**KIRKLEES METROPOLITAN COUNCIL
INVESTMENT & REGENERATION SERVICE**

DELEGATED DECISION TO DETERMINE PLANNING APPLICATIONS

Reference No:	2024/62/90331/E
Site Address:	105, Marsh Lane, Shepley, Huddersfield, HD8 8AP
Description:	Erection of garage and external alterations
Recommending Officer:	Edward Cheseldine

HOUSEHOLDER DELEGATED REPORT

DRAWING NUMBER	CHECKED	REVISION
2024-01-004	MW	B

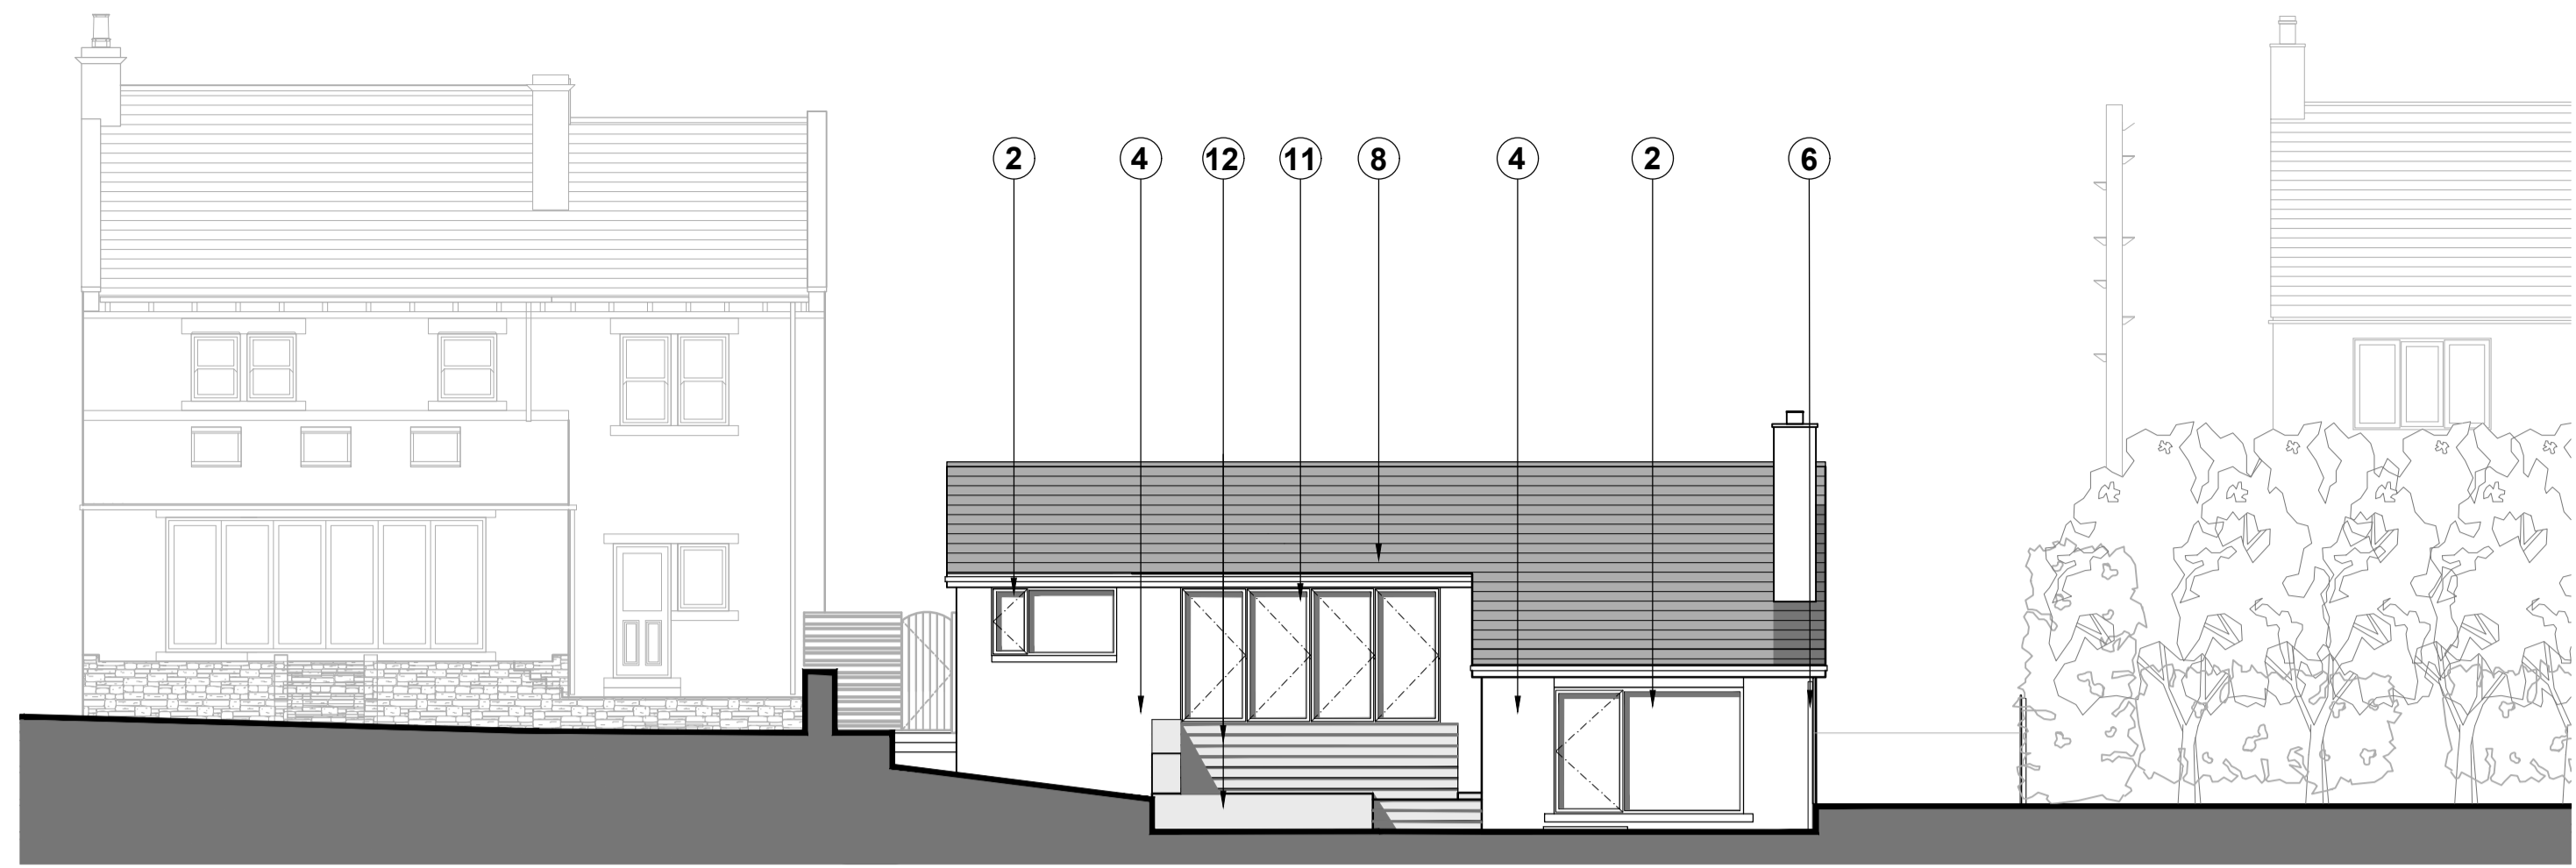
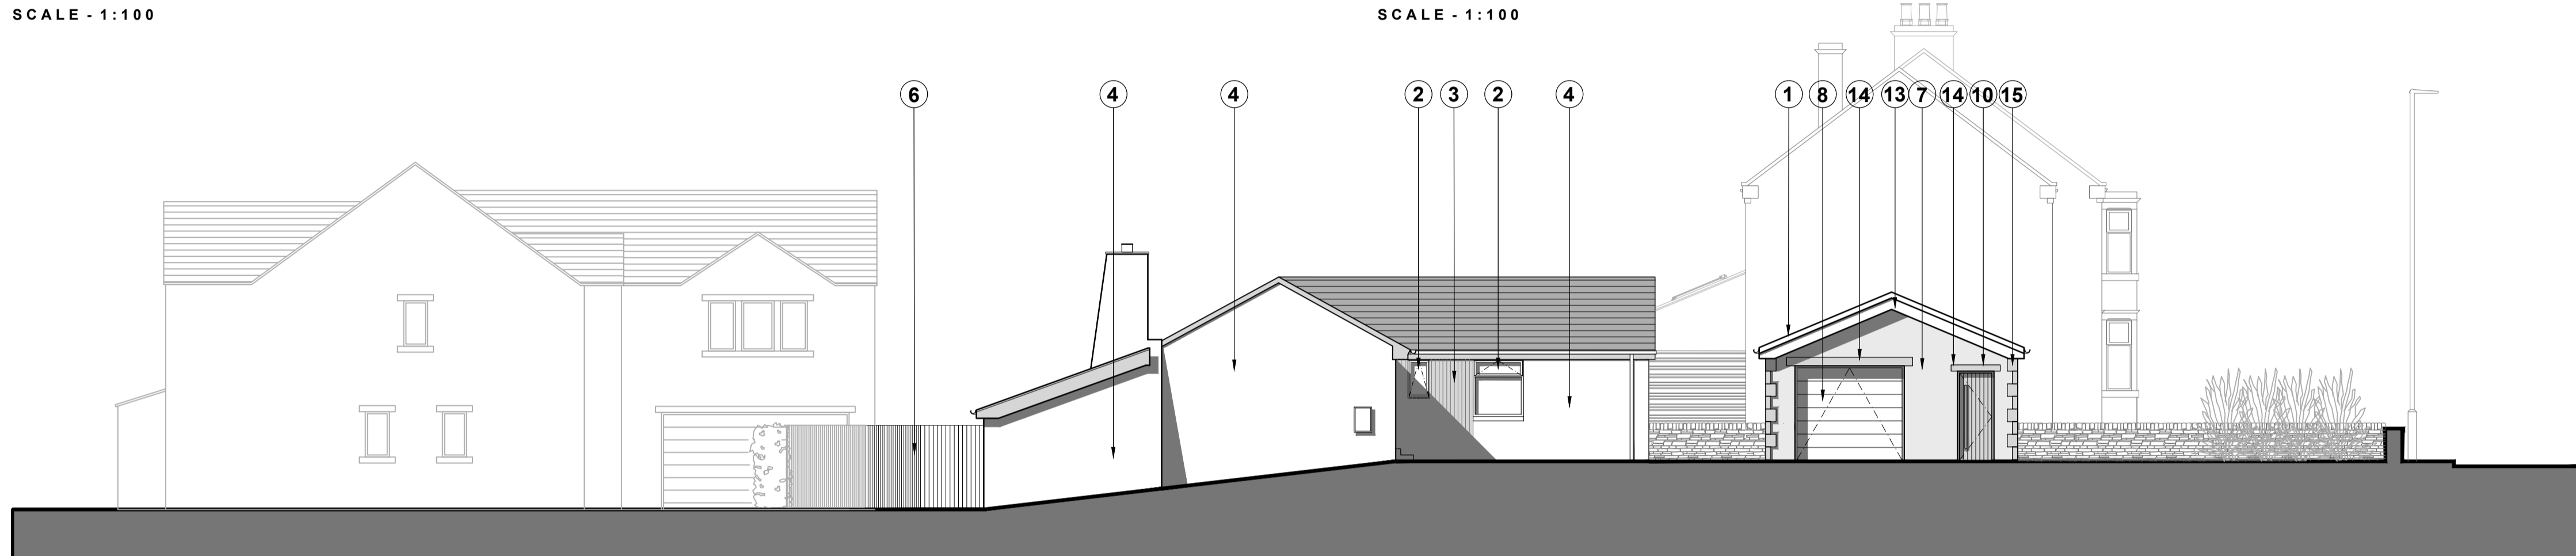
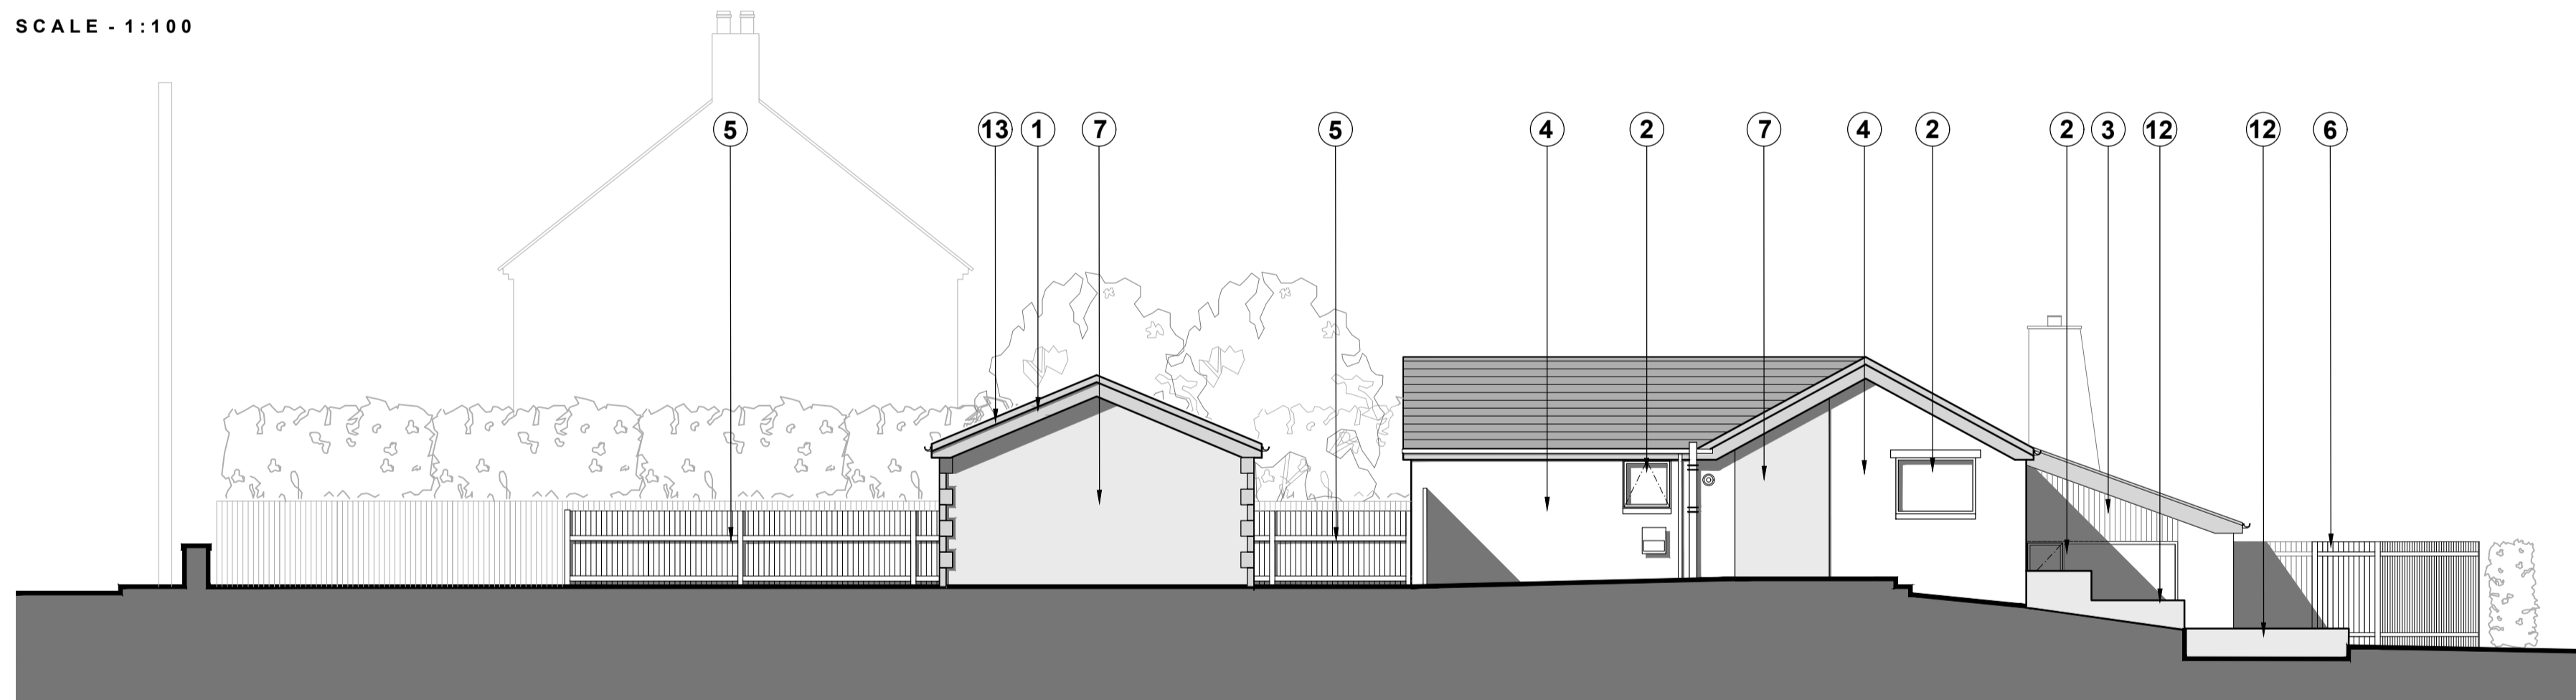
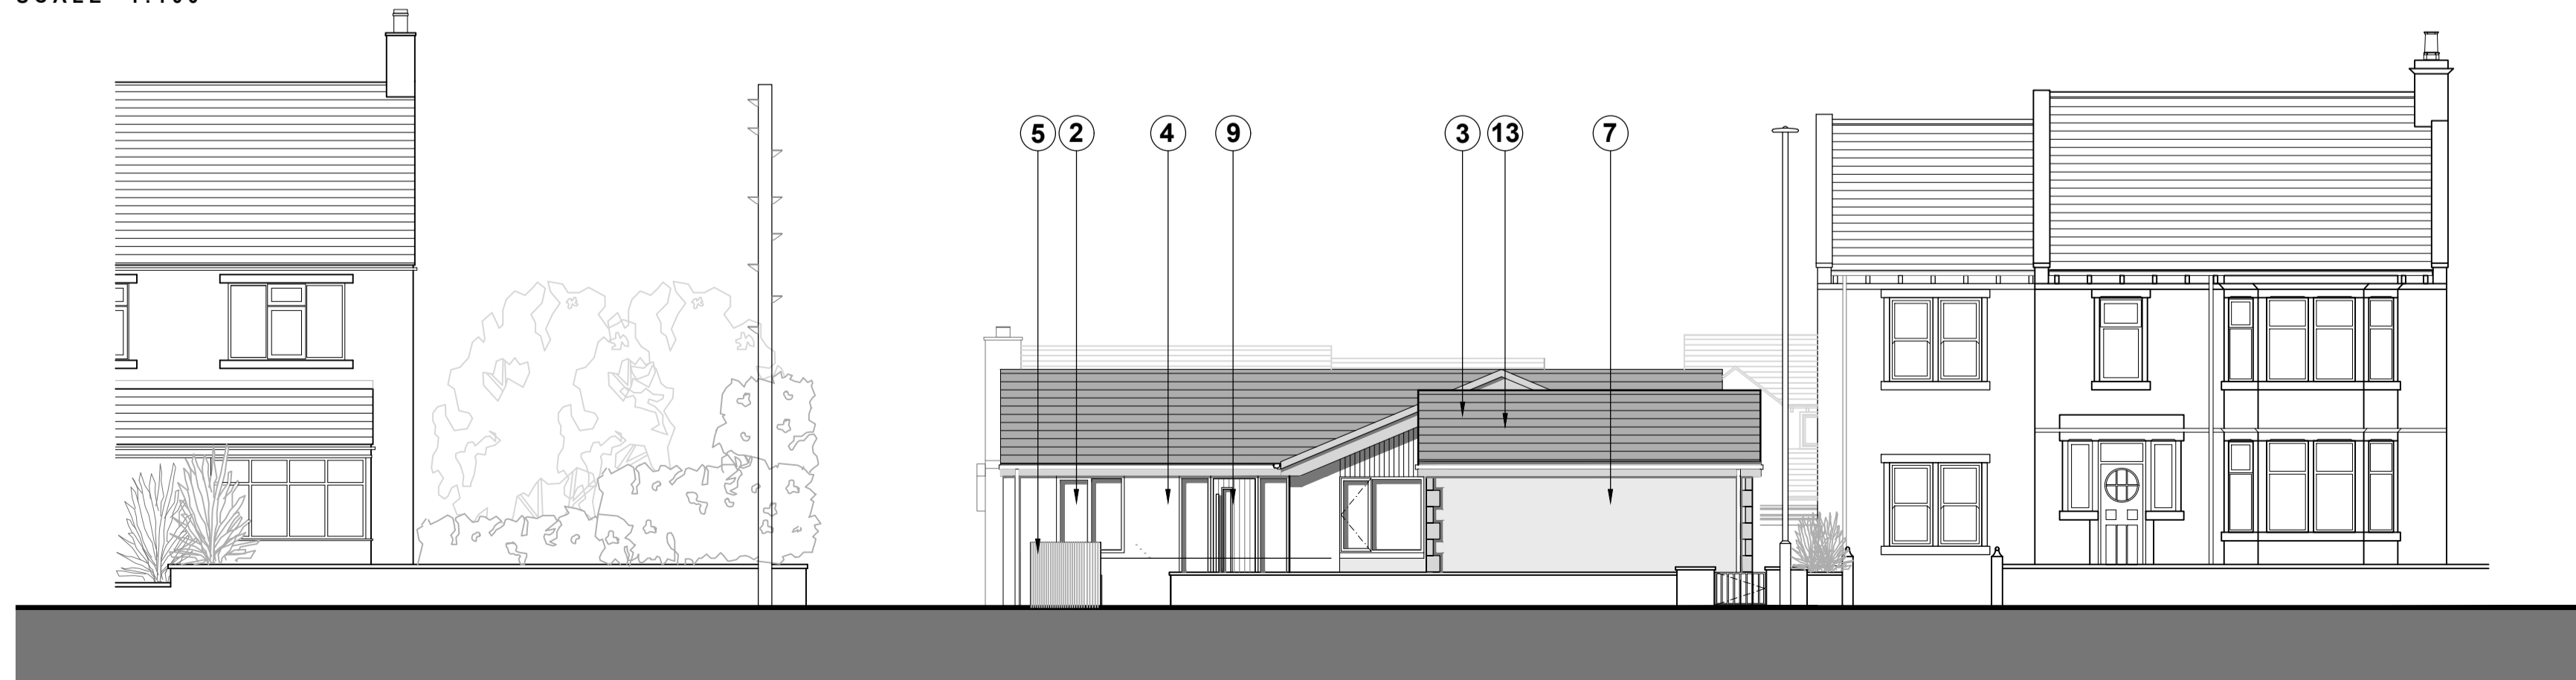
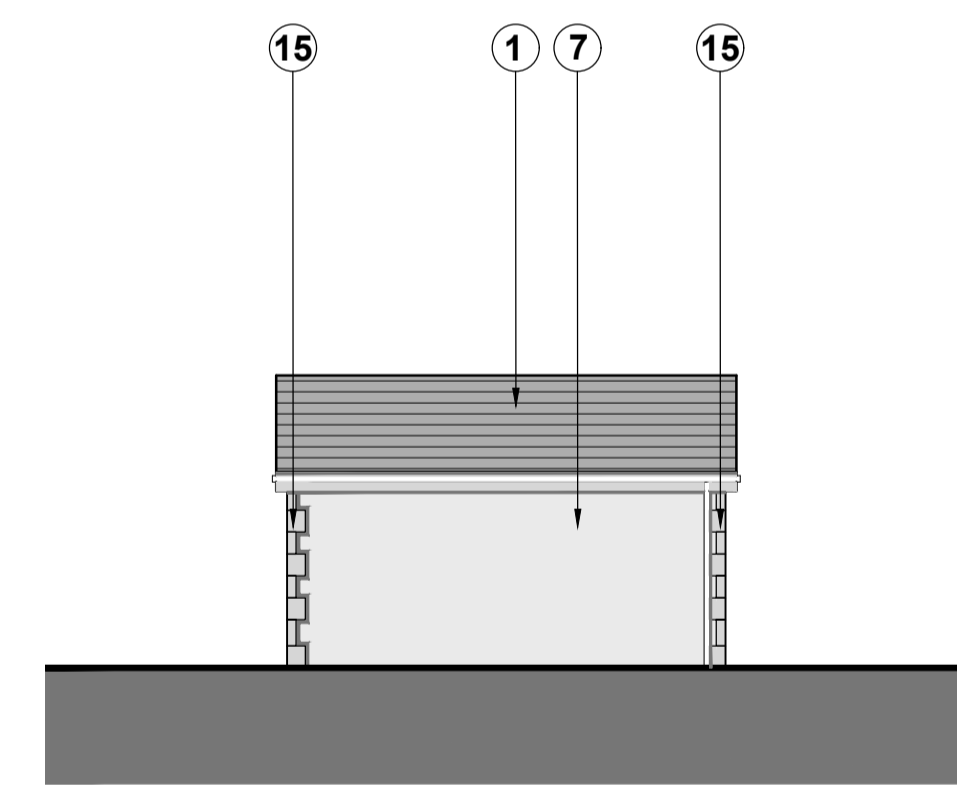
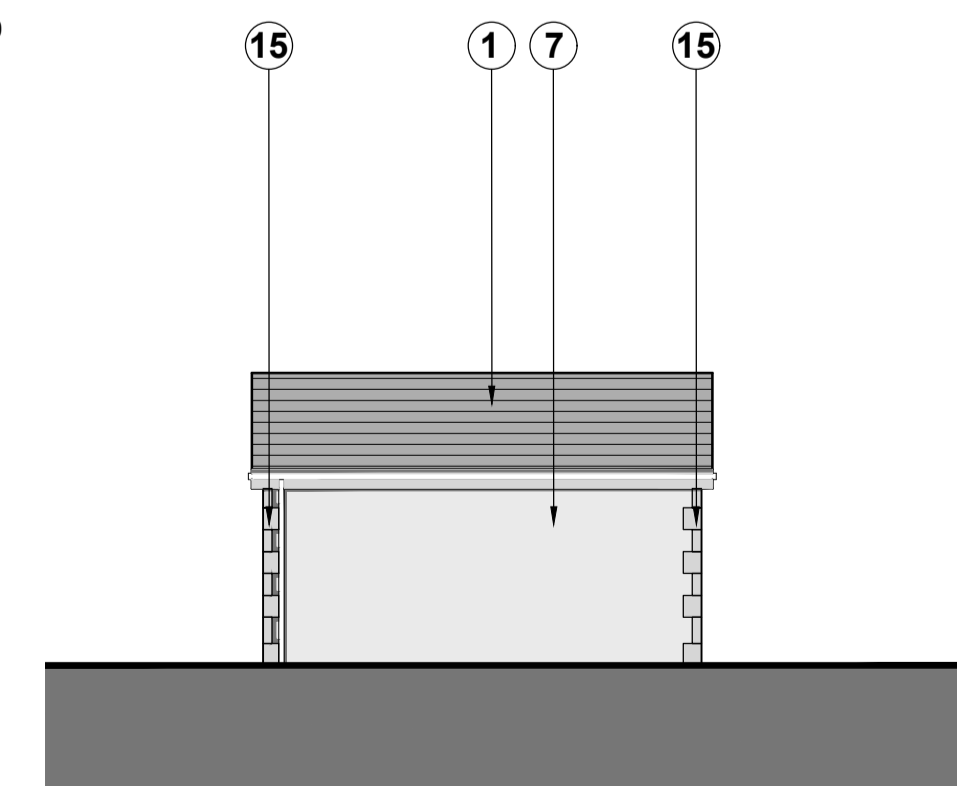
YES / NO	SUMMARY
Negotiations/Amendments during course of application		Yes, the garage has been set back in line with the adjacent properties, quoins have been added to the design of the garage. Fencing to the front of the property has been removed from the plans.
Parish/Town Council comments sought	No

Relevant key design principle (KDP) of the SPD, Policy in the Kirklees Local Plan and the NPPF	Further comments	✓ / X / N/A
Impact on the Local character and street scene	<ul style="list-style-type: none"> • KDP1 of the SPD • Policy LP24 Design (a) and (c) of the KLP • Chapter 12 NPPF 	<p>The garage unit is positioned to the front of the property. It sits ~8.90m from the public pathway and ~1.00m from the boundary to the south-west. The garage is adjacent of the extension of the neighbouring property which is set back behind the original dwelling. The external walls of the garage consist of an off-white render and stone quoins. Due to its position and stone features the garage unit will blend in with the streetscene. Frontal positioned garages are found within other sites on the street.</p>	✓
Impact on original house	<ul style="list-style-type: none"> • KDP2 of the SPD • Policy LP24 Design (c) and (d) of the KLP • Chapter 12 of the NPPF 	<p>A proportion of the front façade will remain visible due to the position of the garage. A garage unit is proposed in a similar position under extant permission 2021/91976. In terms of this material weight can be given to the extant permission for</p>	✓

the positioning of the garage.	
Height, scale and massing	<ul style="list-style-type: none"> • KDP 1 and 2 of the SPD • Policy LP24 Design (a), (c) and (d) of the KLP • Chapter 12 of the NPPF 	The height and scale is such that it does not compete with the adjacent dwellings which form a distinctive character to the street. The ridgeline and part of principal elevation of the original dwellinghouse will still be visible due to the scale which is acceptable.	✓
Facing materials and detailing	<ul style="list-style-type: none"> • KDP 9 of the SPD • Policy LP24 Design (d) (iii) of the KLP • Chapter 12 of the NPPF 	<p>Materials are to be off-white render walls and concrete roof tiles. A single garage door and residential door will be formed on the side elevation.</p> <p>In terms of these, given the position of the garage and stone quoins, the construction is acceptable.</p>	✓
Roof style	<ul style="list-style-type: none"> • KDP 1 and 2 of the SPD • Policy LP24 Design (a), (c) and (d) of the KLP • Chapter 12 of the NPPF 	The roof will be pitched, which although adds height, will make the garage have an appealing architectural design.	✓

Bi-folding doors will be installed on the rear elevation of the dwelling. There are currently large window openings and a conservatory on the rear elevation of the building. As part of the proposal the conservatory will be removed from the rear and replaced with the bi-folding doors. The level of glazing is acceptable given it will replace a glazed conservatory.

Timber decking and stone pavers are proposed to the rear of site, which will remove a substantial section of lawn, therefore introducing a significant amount of hardstanding to the property. Outdoor space to the front of the property will remain, with a minimal lawn to the rear. A 2.00m fence will be erected to the rear. Due to the screening, the decking and pavers is acceptable.

Render will be introduced on sections of the exterior walls of the property. It will provide a visual break to the brick-built dwelling. There is rendering within the building group. The modification is acceptable.
